Our reference: ECM: 9339609
Contact: Kate Smith
Telephone: 02 4732 7705

Response to Notification of SSD7308 - MOD 1 – Rail Siding Refurbishment Works, Amended Development Footprint, Construction Compound, Stormwater Management Works and Revised Access Arrangements at 2 Forrester Road ST MARYS

Figure 10 | Proposed stormwater infrastructure for northern section of rail refurbishment works (Source: Applicant's Stormwater Management Design)

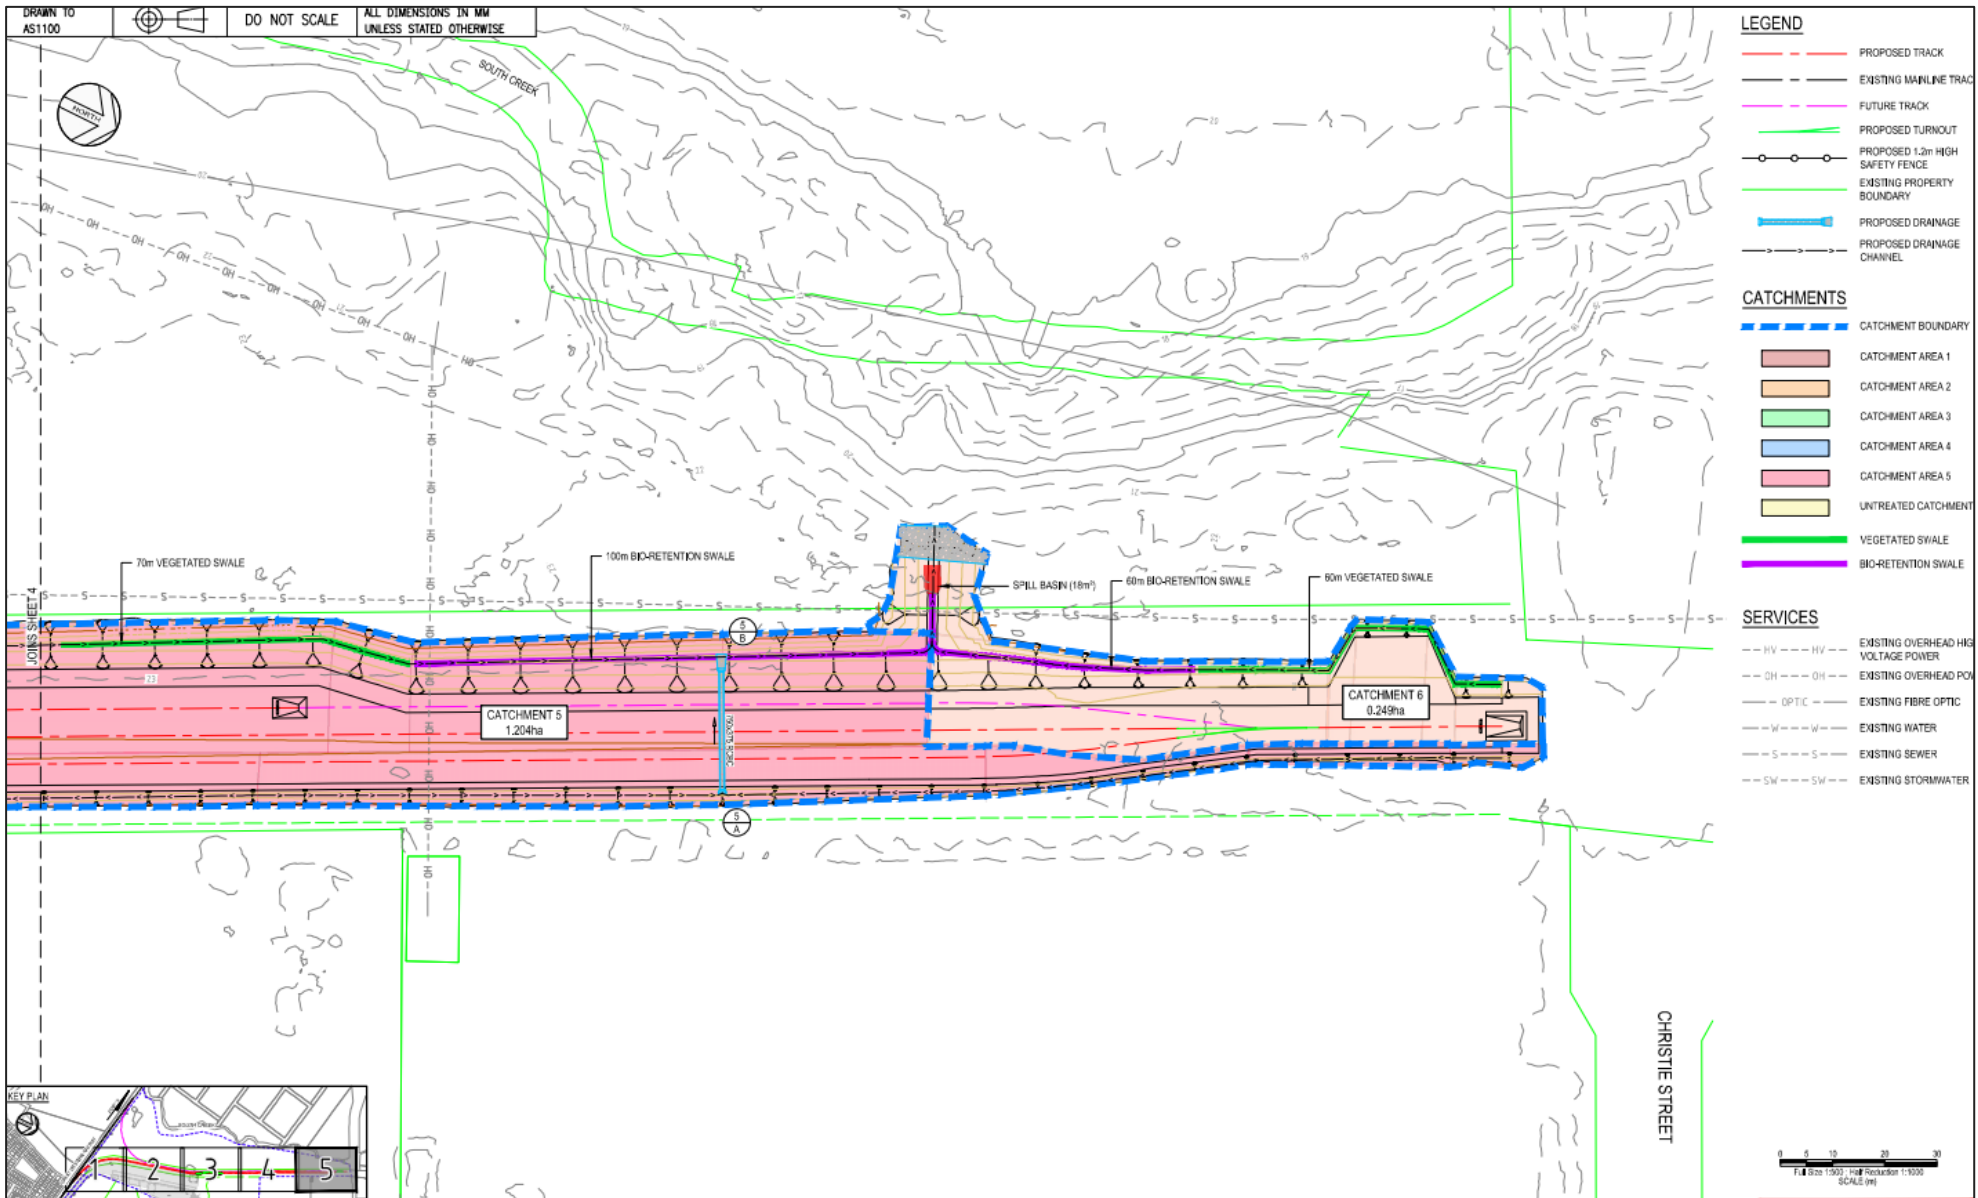
Stormwater drainage is acceptable as it proposed to drain the siding via grass channels that discharge into longitudinal bio-retention systems (subject to concurrence from Council's Waterways Team).
